**ESR Horsley Logistics Park Modification 4 (SSD-10436-Mod-4)
Request for additional information**

I refer to the Modification Application for the ESR Horsley Logistics Park (SSD-10436-Mod-4).

Figure 1 Lot 204 Proposed Site Plan

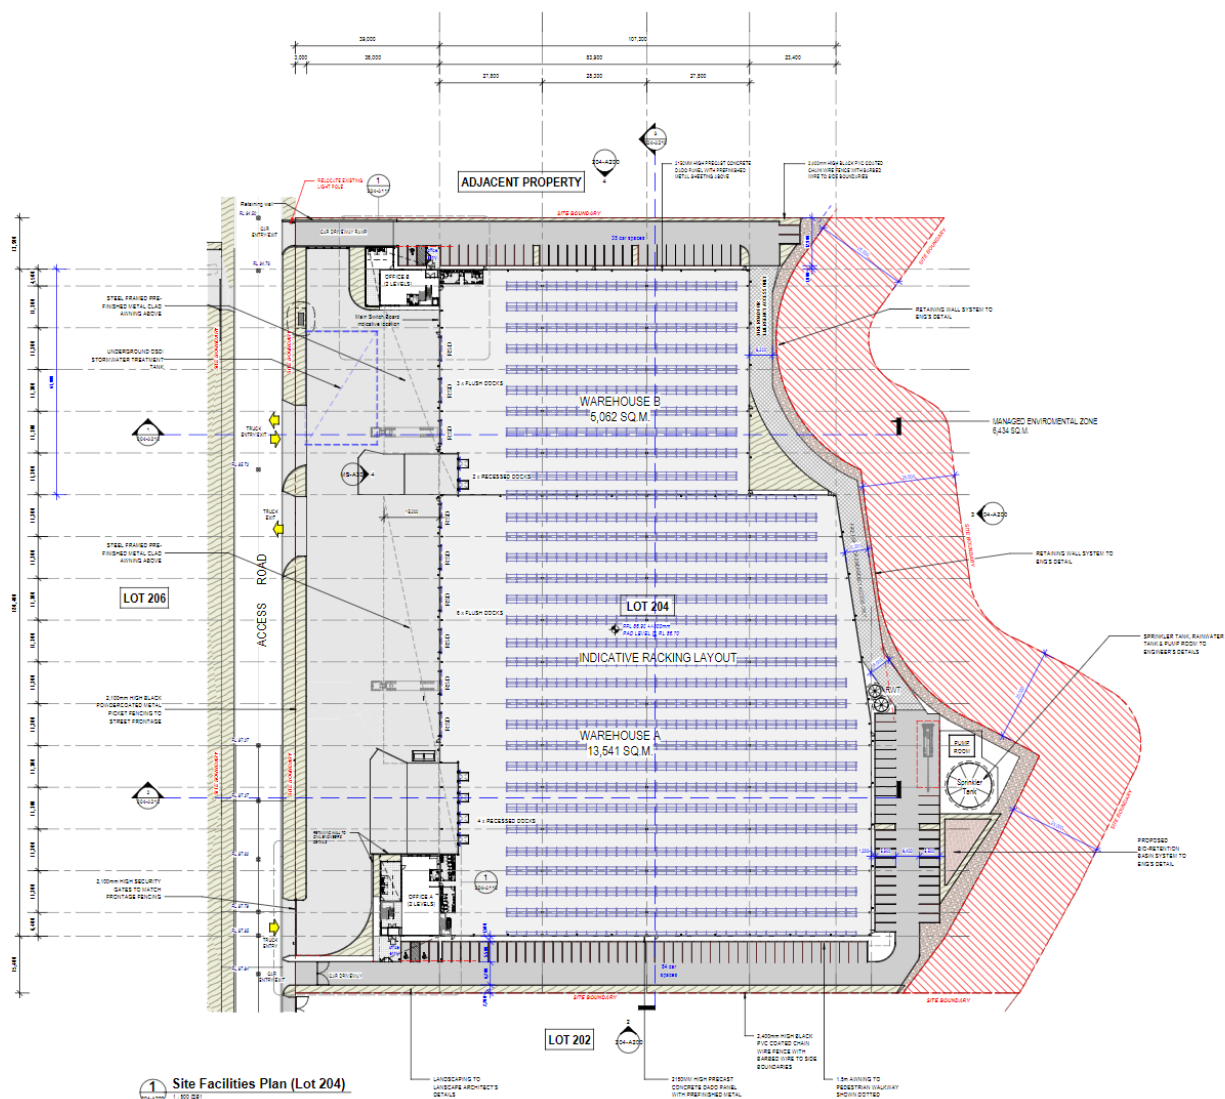
2. The Modification Report inconsistently describes the reduction in the building pad proposed for Lot 204. Section 1 states the building pad would be lowered by 2 m, whereas Sections 4.2 and 6.1 states it would be lowered by 2.8 m. Please clarify the proposed Lot 204 building pad reduction.

Figure 2: B-double Exit Movements at Warehouses A and B

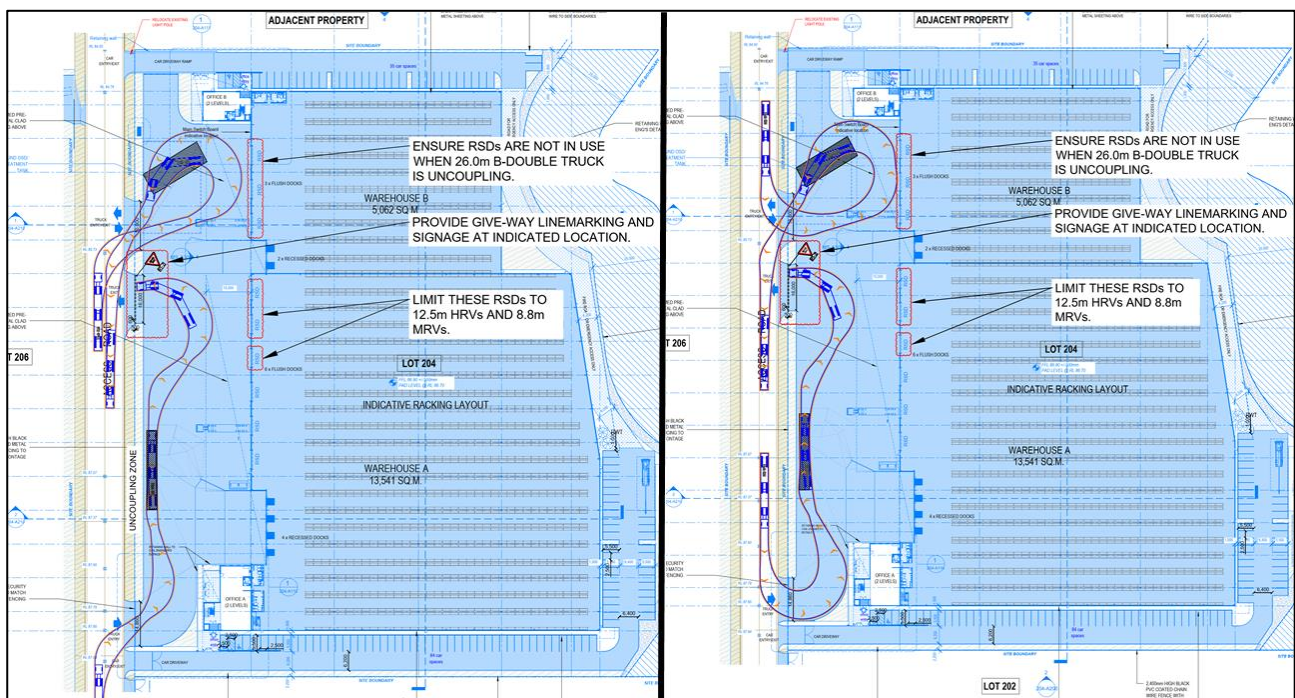
6. The Department notes the modification includes two truck entries / exits at Lot 204 adjacent to each other on Johnston Crescent. Given Johnston Crescent will carry two-way traffic and connects to Old Wallgrove Road in the future, the Department raises concerns about manoeuvrability and road safety at the proposed truck accesses at Lot 204. Should two 26 m B-Doubles associated with two tenants use the accesses concurrently, there is a potential

conflict of movements at the accesses and potential impacts on other road uses travelling north-bound and south-bound on Johnston Crescent. Please clarify the manoeuvrability at the proposed truck accesses including swept path diagrams showing 26 m B-Doubles for both tenancies manoeuvring at the same time and any additional mitigation measures to ensure road safety where applicable.
